From: Lisa Jackson <[REDACTED]>
Sent: 11 April 2022 07:43
To: Simon Davis
Subject: Fwd: Planning Consultation on: Y/32/22/DOC
Attachments: 13591-CRH-XX-XX-CA-C-0007-P1_Proposed SW Network calcs.pdf; 13591-CRH-XX-XX-DR-C-5050-P7_Proposed Drainage Layout (Sheet 1).pdf; 13591-CRH-XX-XX-DR-C-5260-P1_Subcatchment Plan.pdf; suds-design-and-adoption-guide (extract).pdf; 13591-CRH-XX-XX-DR-C-5051-P6_Proposed Drainage Layout (Sheet 2).pdf

Subject: RE: Planning Consultation on: Y/32/22/DOC

Engineers Comments Regarding Surface Water Drainage

Headwall Outfall to Watercourse

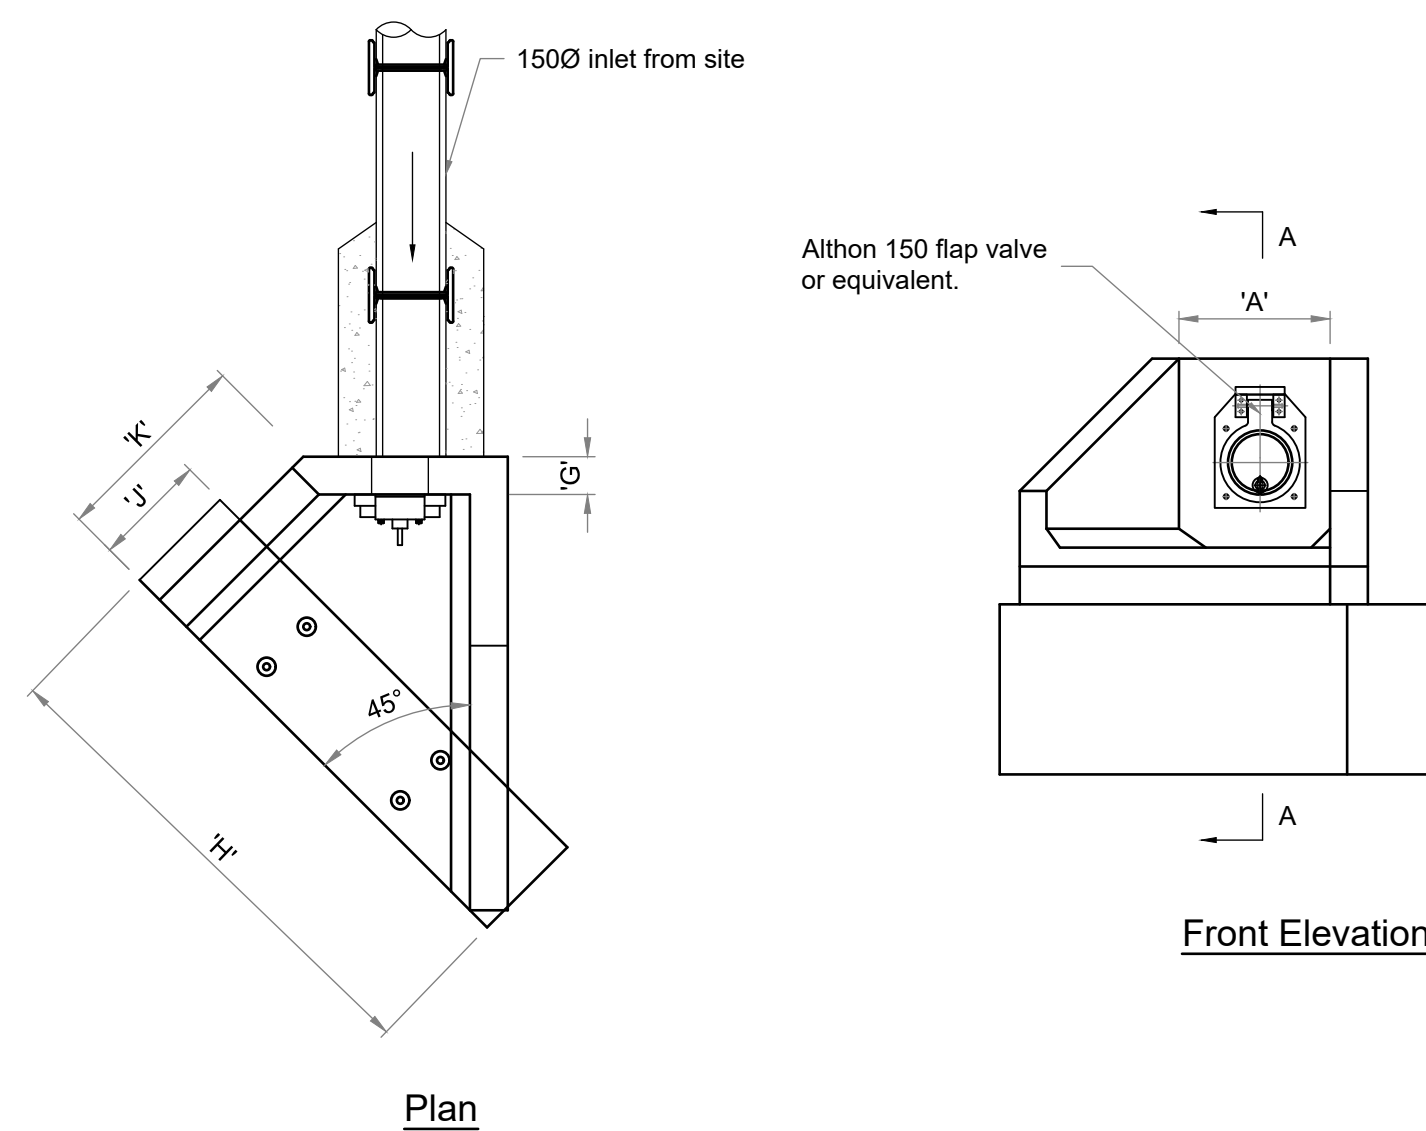
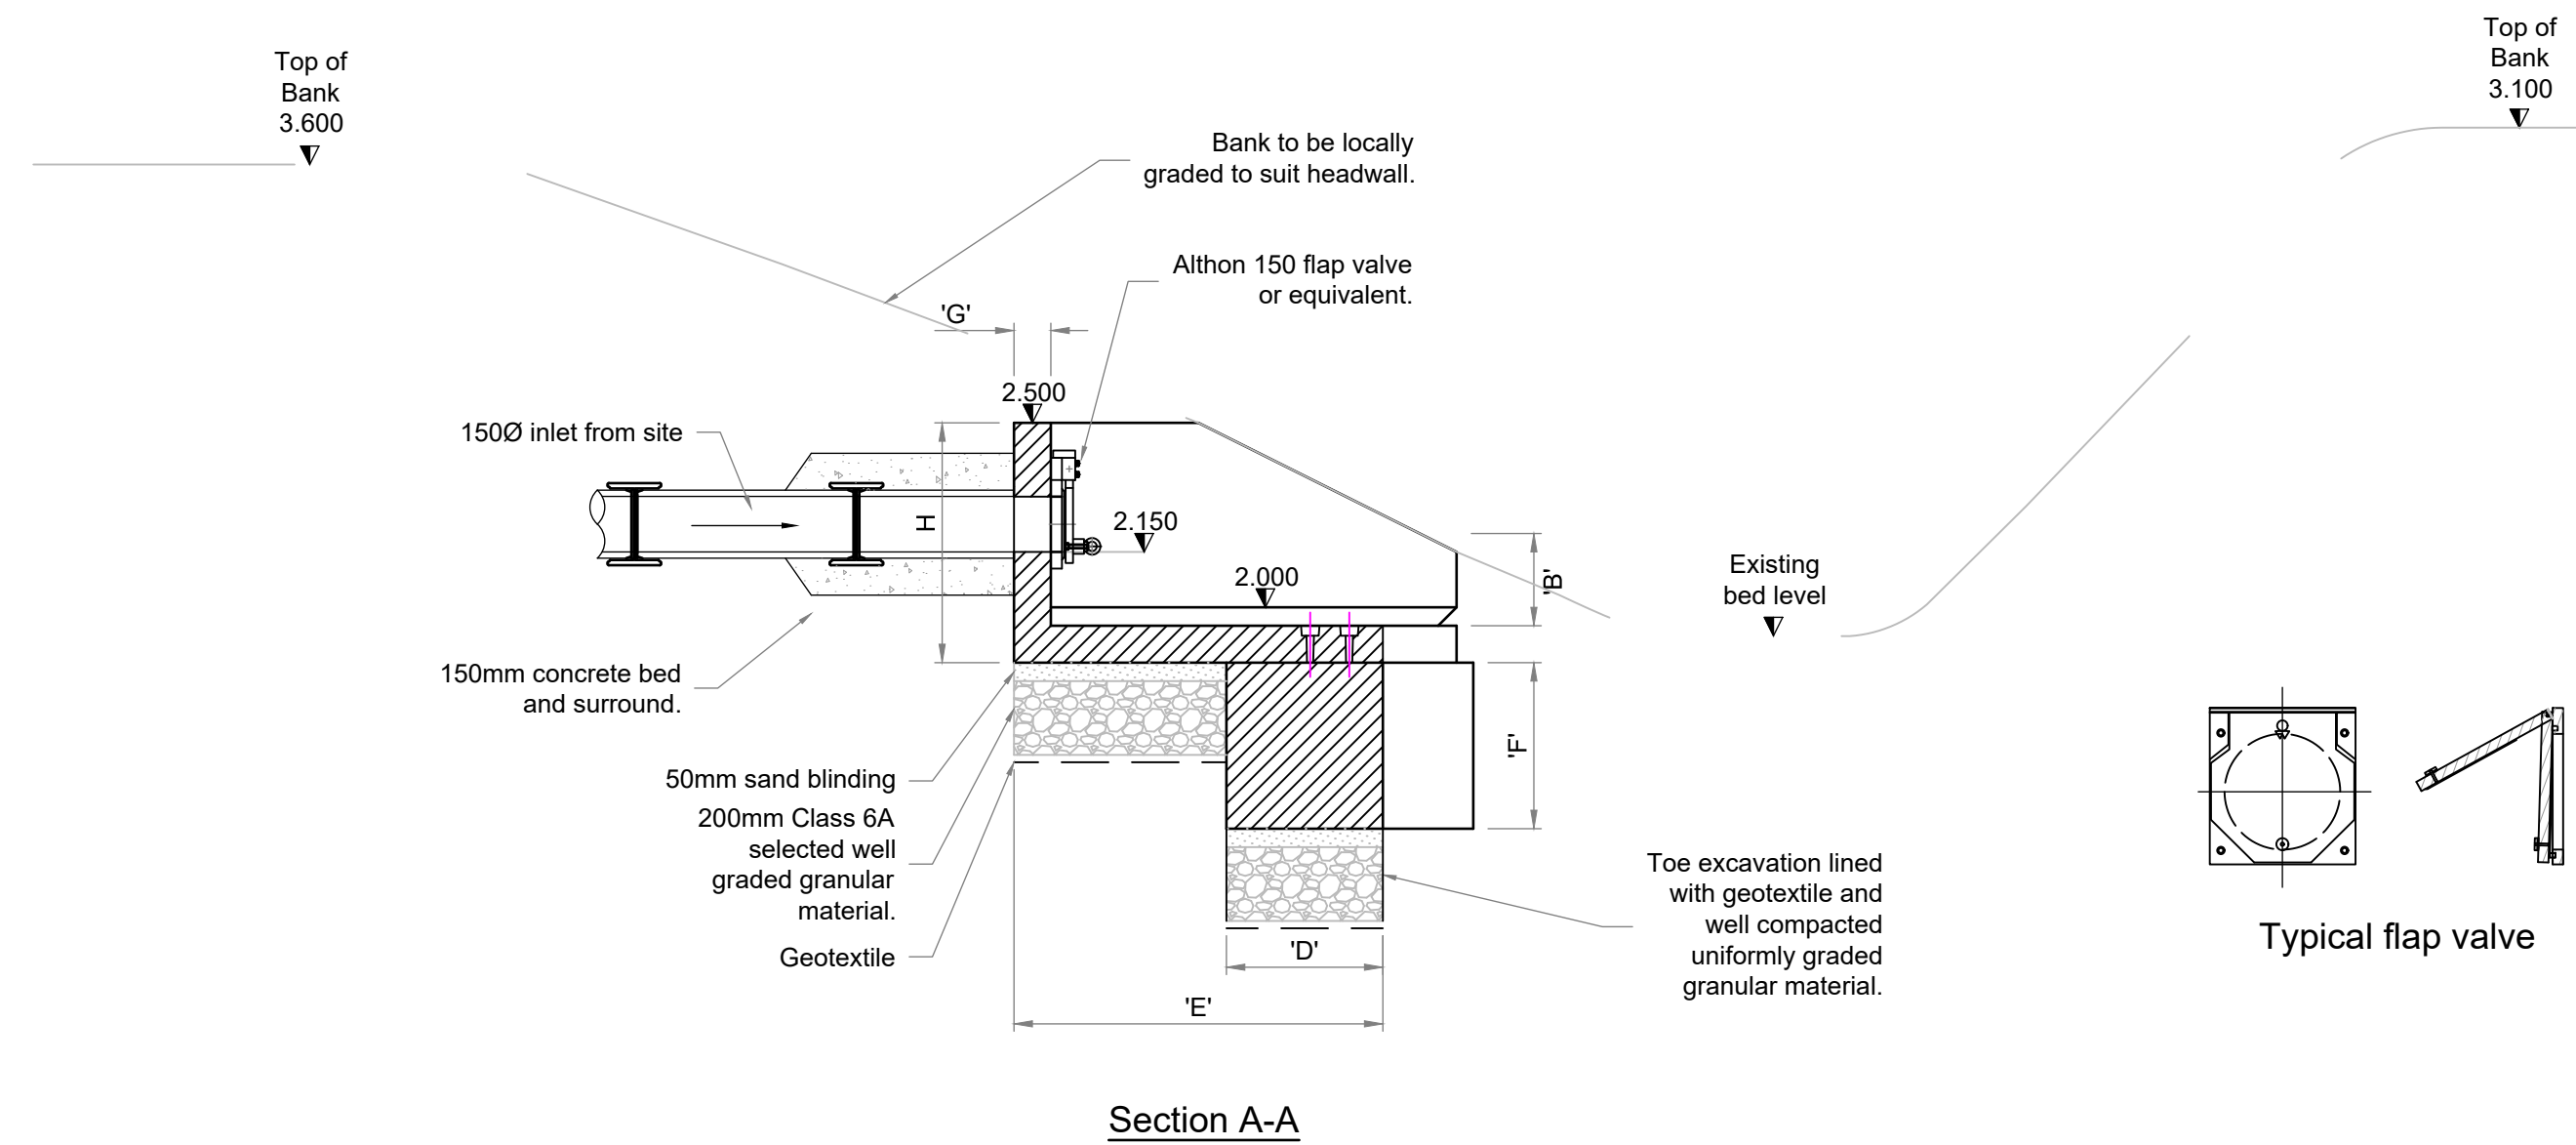
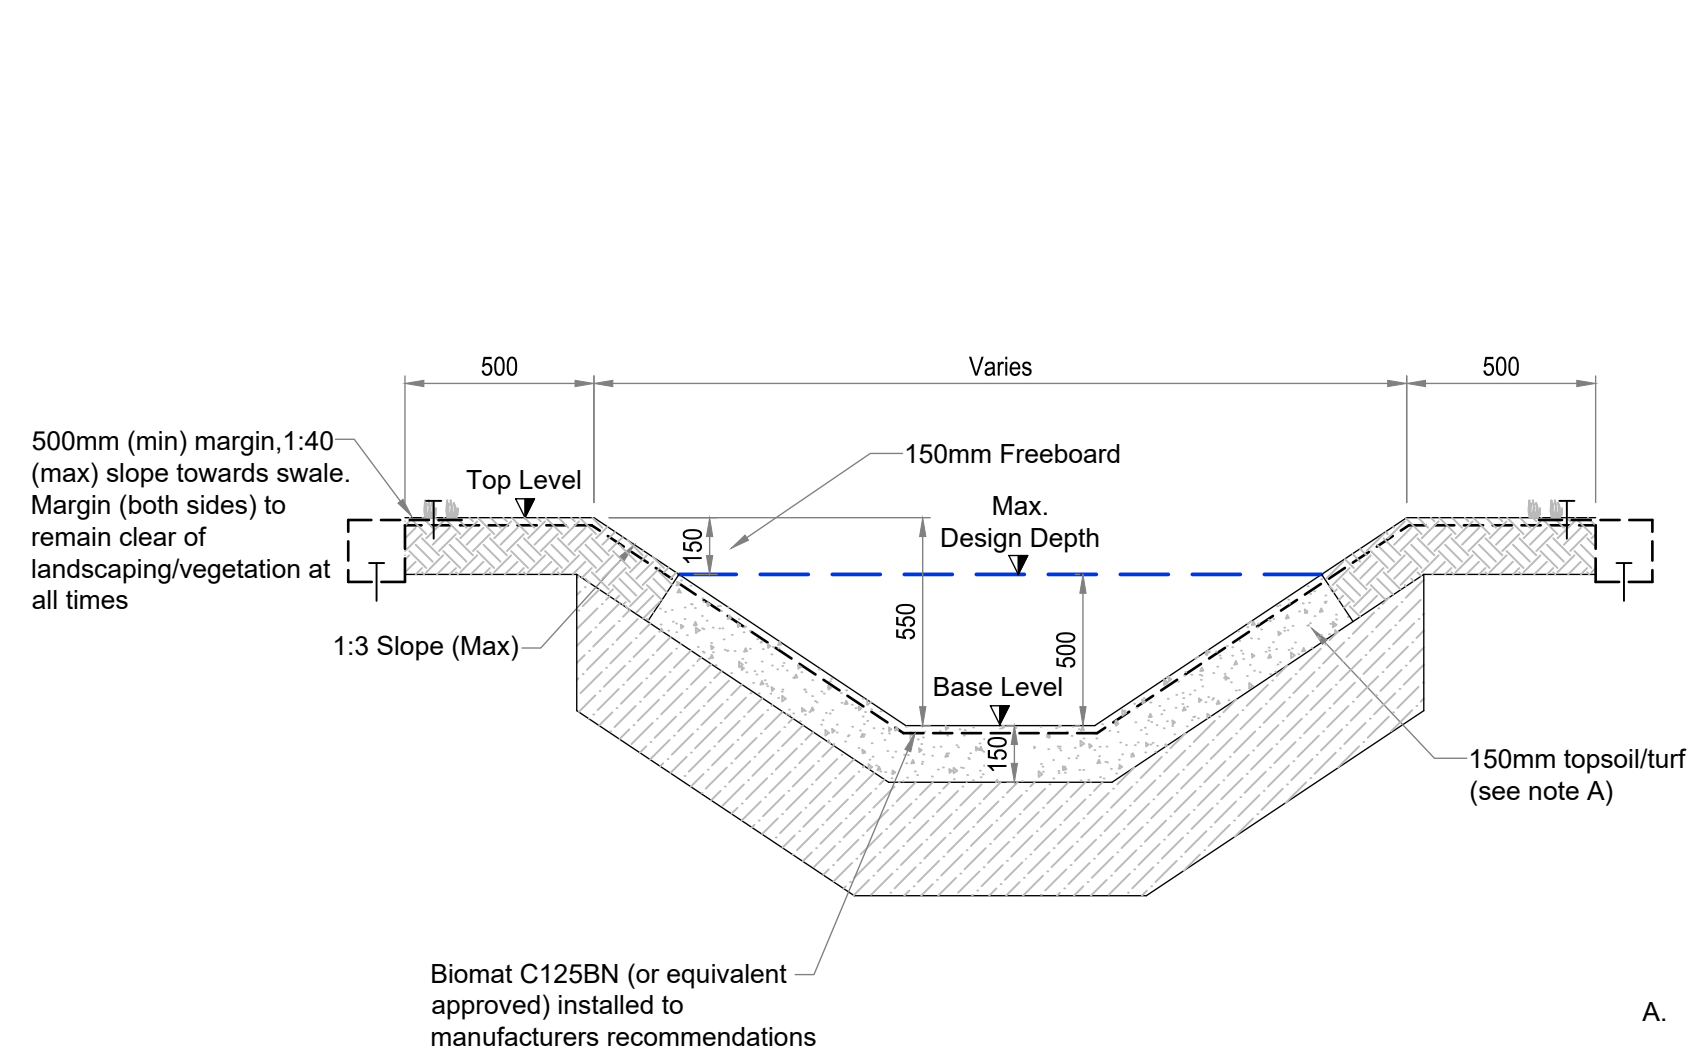
8. The gabion outfall construction detail drawing is unclear. Is it proposed to have buried pipes discharging to the basin? The gabion basket is to be built into the embankment and to be exposed so as to be accessible for maintenance. The pipework will be within the basket and wrapped in a permeable membrane to prevent build-up of fines. The gabion provides siltation protection as well as dispersal of incoming flow to reduce scour. The gabion basket also removes the need for a traditional headwall and grille, reduces the maintenance requirements and provides a bigger area of contact/surface flow. *Pipework should be exposed and within headwalls. To bury pipework within a gabion will prevent visual inspections for blockage being undertaken. The permeable membrane surrounding the pipe and gabion will likely silt up. Design must be maintainable. The gabion basket headwall is designed to minimise impact to the visual impact vs traditional precast concrete headwall units while allowing free flow of water. The headwalls proposed have been successfully utilised on other schemes and have been encouraged by other drainage authorities; an example can be found on page 76 of the Cambridge SuDS design and Adoption Guide (attached for reference).*

Project No.	Originator	Volume	Lvl/Loc	Type	Role	Number	Rev
13591	CRH	XX	XX	DR	C	5050	P6

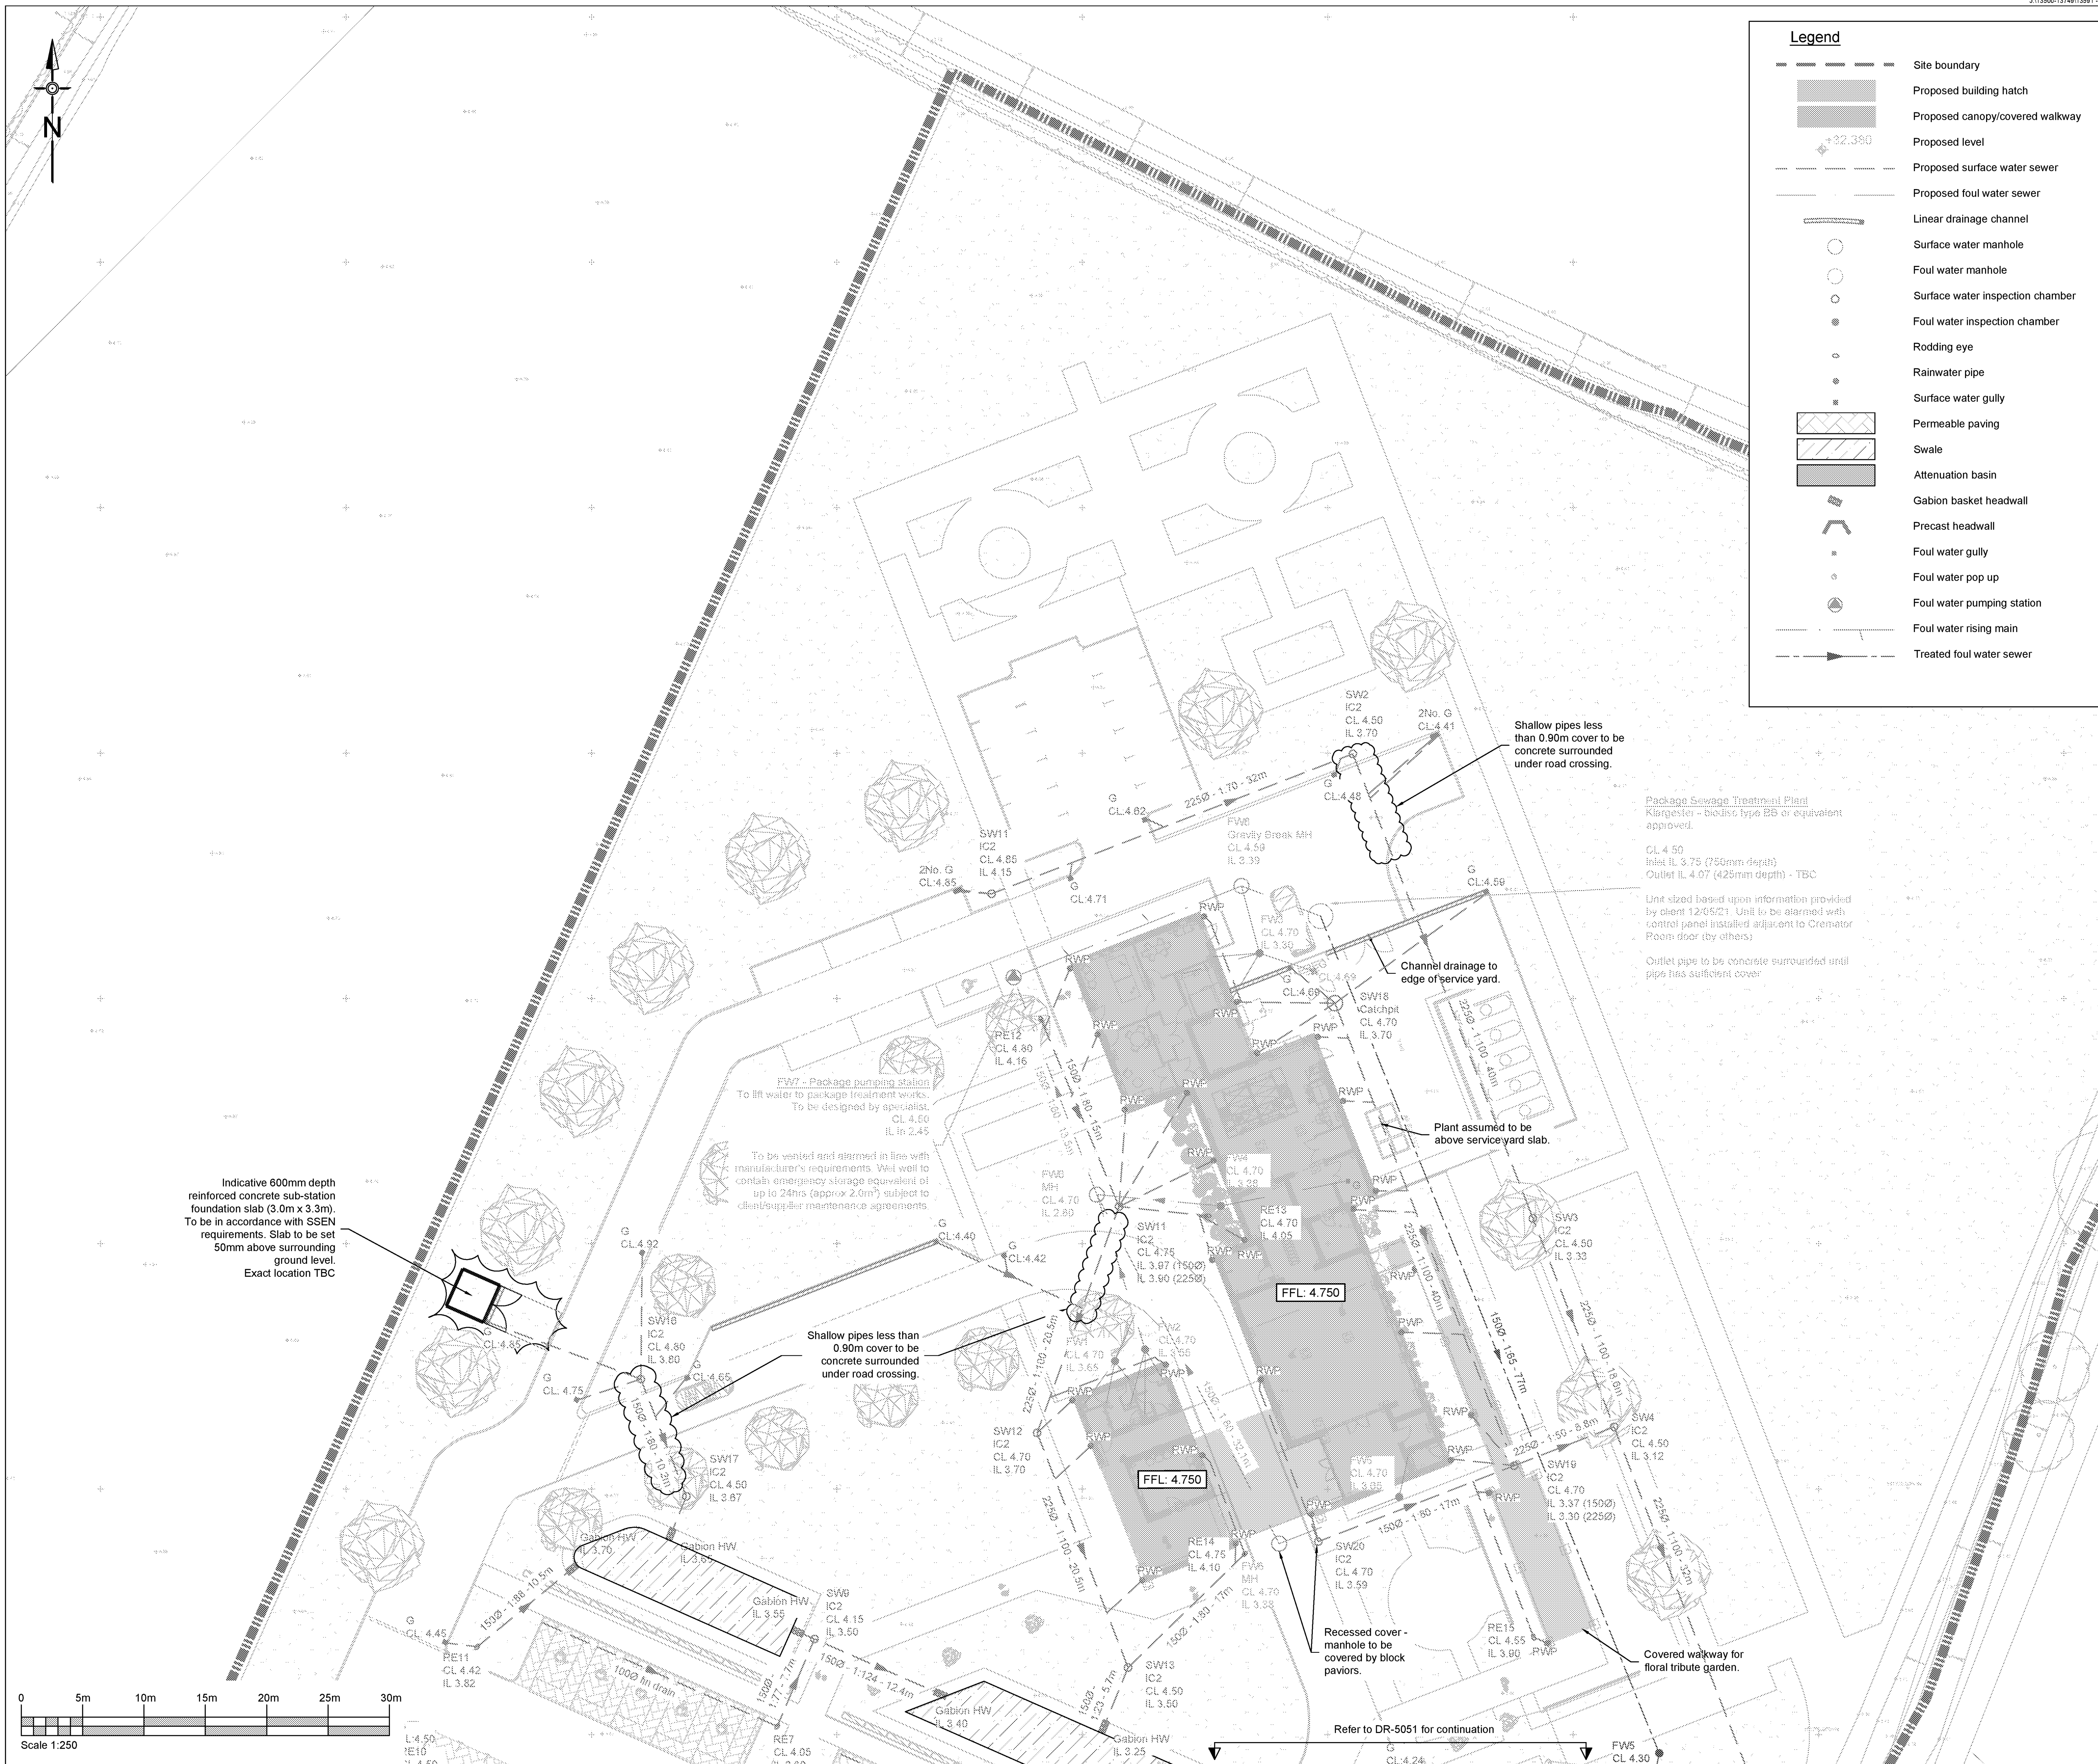
4. Please label all pipes with diameter and fall. Additional pipe labels have been added to drainage layout plans 13591-CRH-XX-XX-DR-C-5050 Revision P6 and 5051 Revision P5. Gradients for short (<5m) pipe lengths have not been shown. Pipe sizes, maximum grades and materials are to be as specified on drainage notes drawing 13591-CRH-XX-XX-DR-C-5300 Revision P1 previously provided. Okay.

Finish and formation levels of permeable paving must be detailed, thank you for providing a finished levels plan, please provide formation levels on layout plan, this is required to evidence adequacy of proposed connections from permeable paving. And to ensure correct construction. Formation levels of porous sub base of permeable paving have been added in green text to drawings DR-5050 and 5051 as requested.

7. Gullies and channel drains should be labelled with cover levels. Cover levels have been provided for proposed gullies on updated drainage layout plan 13591-CRH-XX-XX-DR-C-5050 Revision P6 and 5051 Revision P5. Channel drain cover levels will necessarily vary along the length and hence have not been provided. Exact levels will be determined by contractor to suit the finished levels as shown on levels plan 13591-CRH-XX-XX-DR-C-5200 Revision P3. *Levels should be provided on plan to ensure construction is carried out in accordance with proposals. Channel drain cover levels have been added to drawings DR-5050 and 5051 as requested.*

2. *Please supply a buffer plan to show that at least 3m is being provided between top of bank of watercourses and obstructing features, such as fences, buildings, and basins. A suitable buffer has been provided between top of basin and edge of watercourse to allow for maintenance, as shown on drawing 13591-CRH-XX-XX-DR-C-5051 Revision P5. Buffer not clearly shown, please show the buffer on a plan. A buffer has been shown on drawings DR-5050 and 5051 as requested.*
